Fire Marshal Division

**Re: Whitey's Country Store
4298 Christian Light Rd.
Fuquay-Varina, NC 27526**

Application Number BCOM1904-0004

FLOOR PLAN
 SCALE: 1/4" = 1'-0"

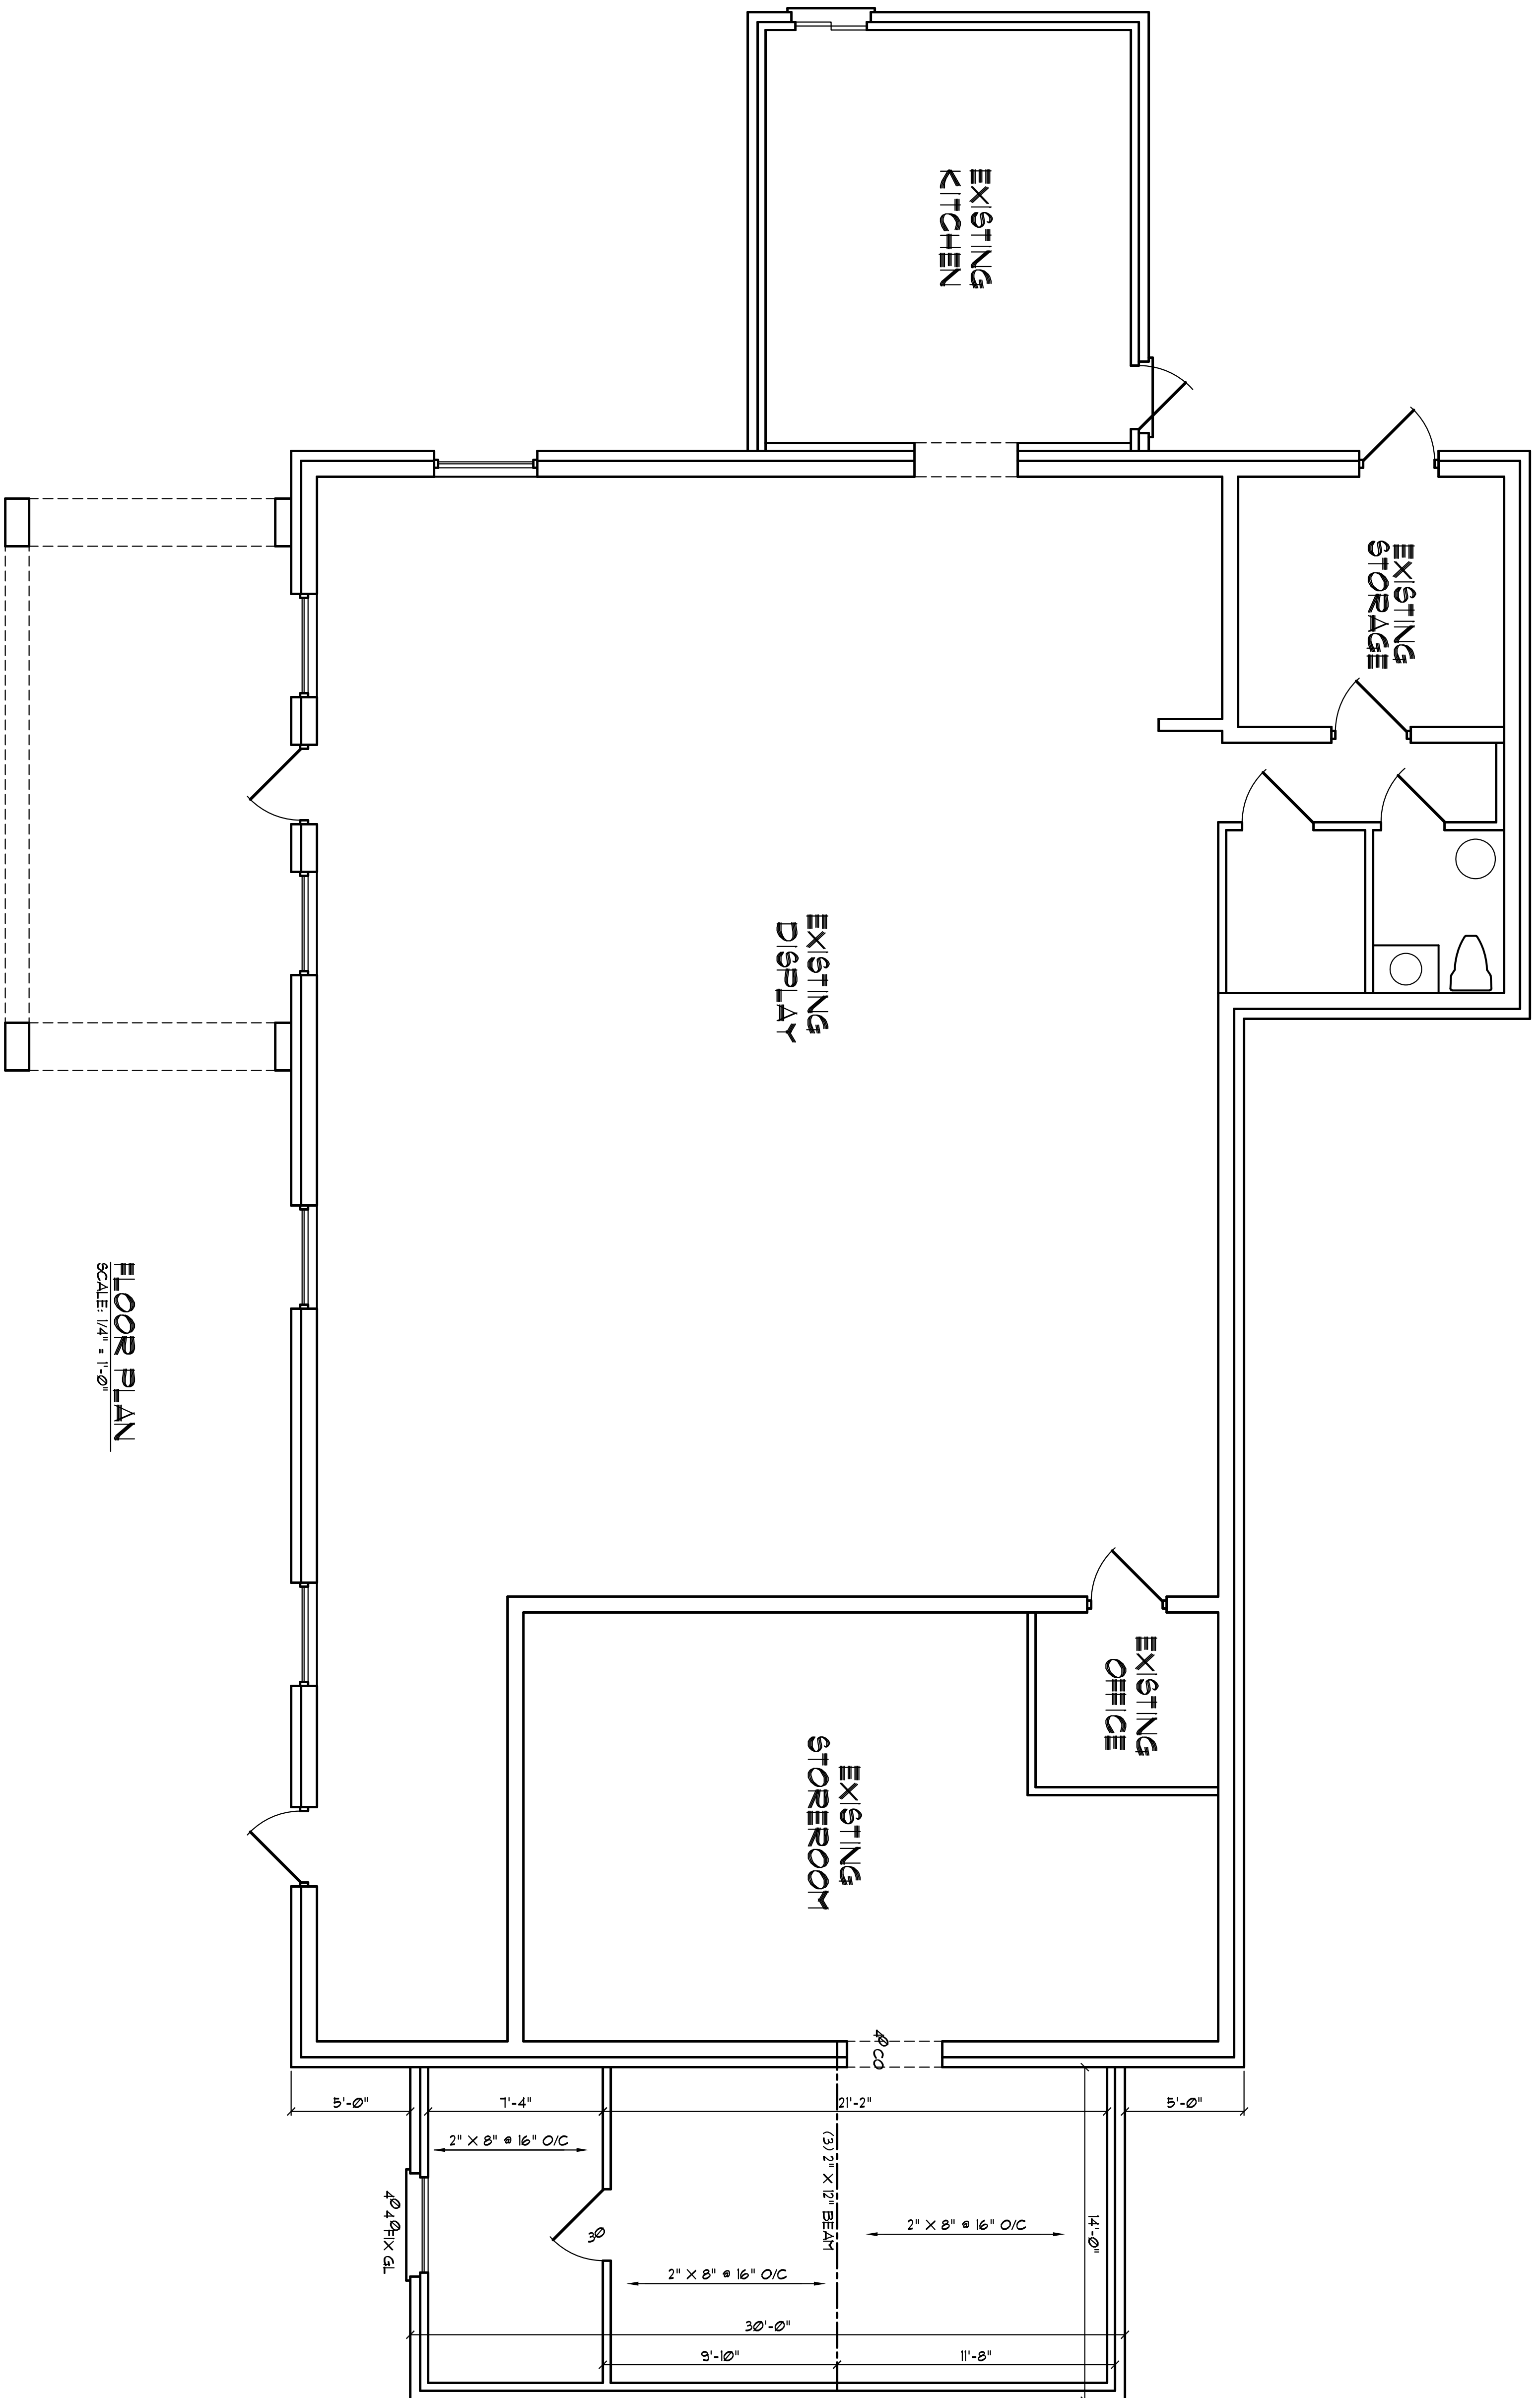
- **The plans don't show an approved means of egress from the addition and/or the existing storage area. Please clarify as one is required.**
- **Please schedule all inspections through the Fire Marshal's Office. 910-984-4003.**
